**Redevelopment of the IMAX Theatre and Surrounding Public Domain Upgrades  
Darling Harbour (SSD 7388) - Notice of Exhibition**

Thank you for your letter dated 25 January 2016, requesting Transport for NSW (TfNSW) review and comment on the above development application.

LONG RIGID BUS metres

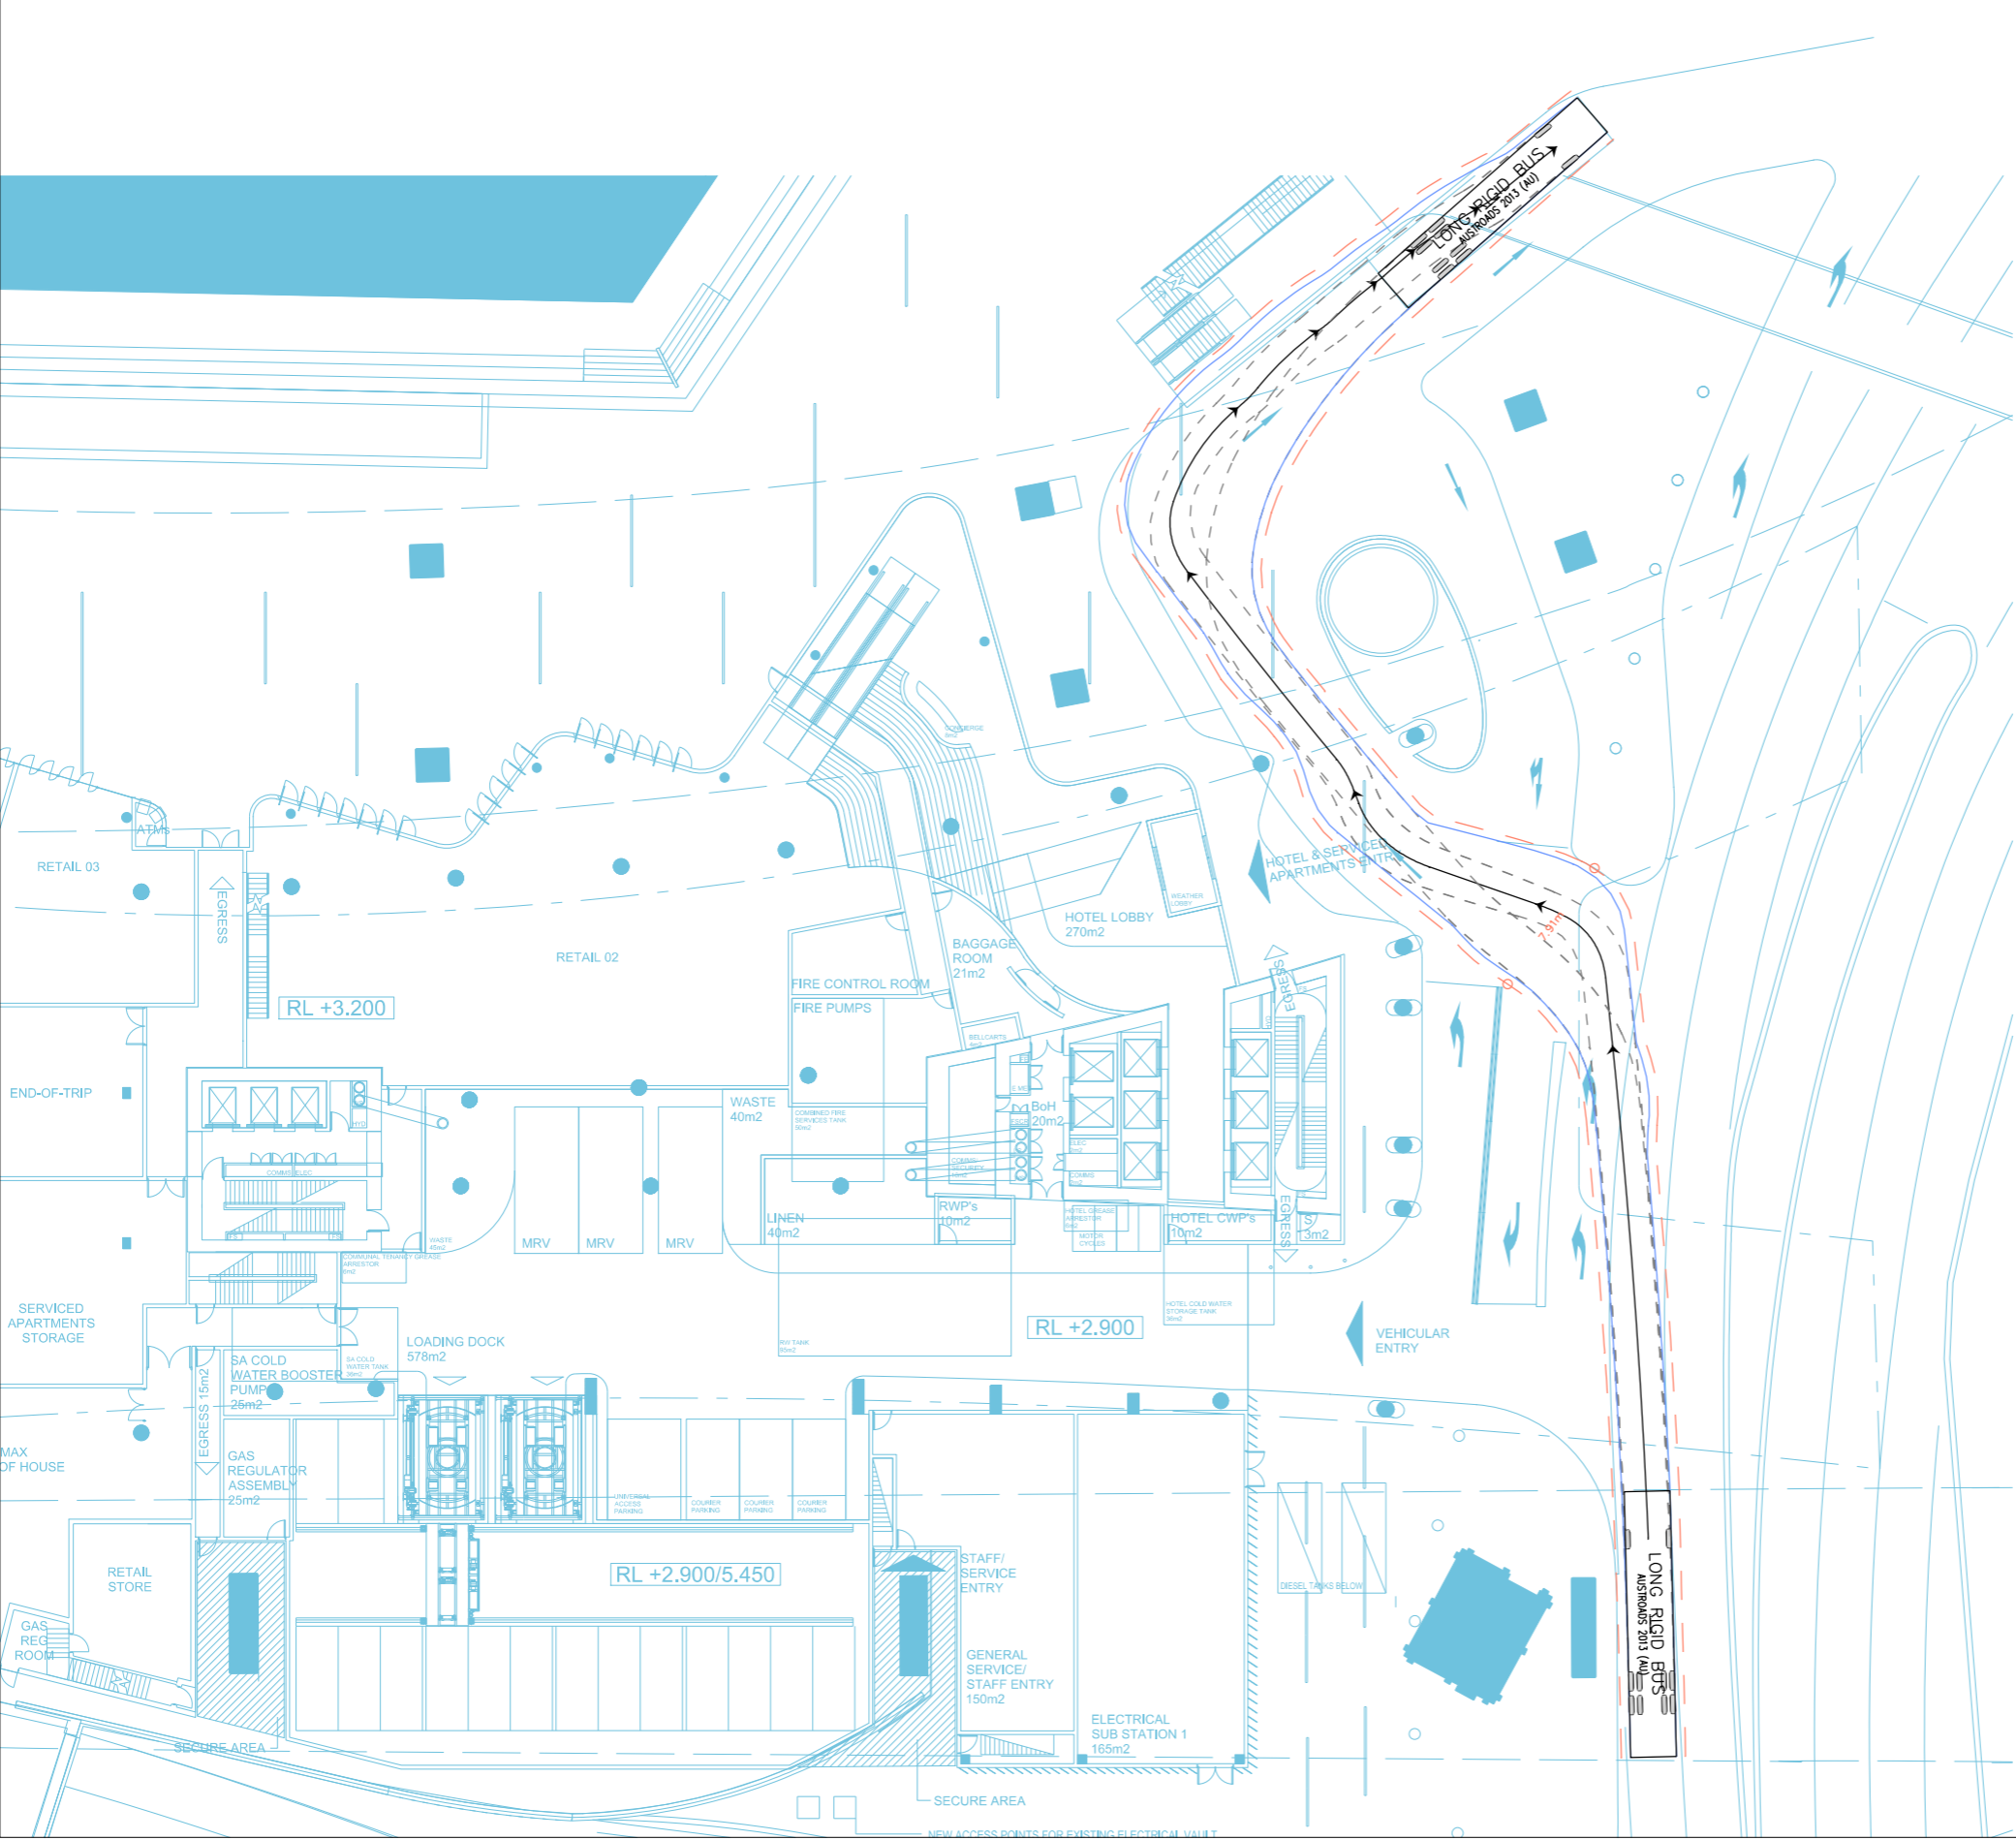
In addition, swept turning path shows that a bus will not be able to pass if another vehicle has already stopped in the porte cochere. It also shows that a bus will not be able to make the last turn near the pedestrian bridge steps as indicated on the plan.

From the swept path analysis it does not appear that a bus could access the bus zone if there are vehicles parked on entire length of the western side of Wheat Road. The design of Wheat Road/ porte cochere should be revised to ensure buses can be accommodated.
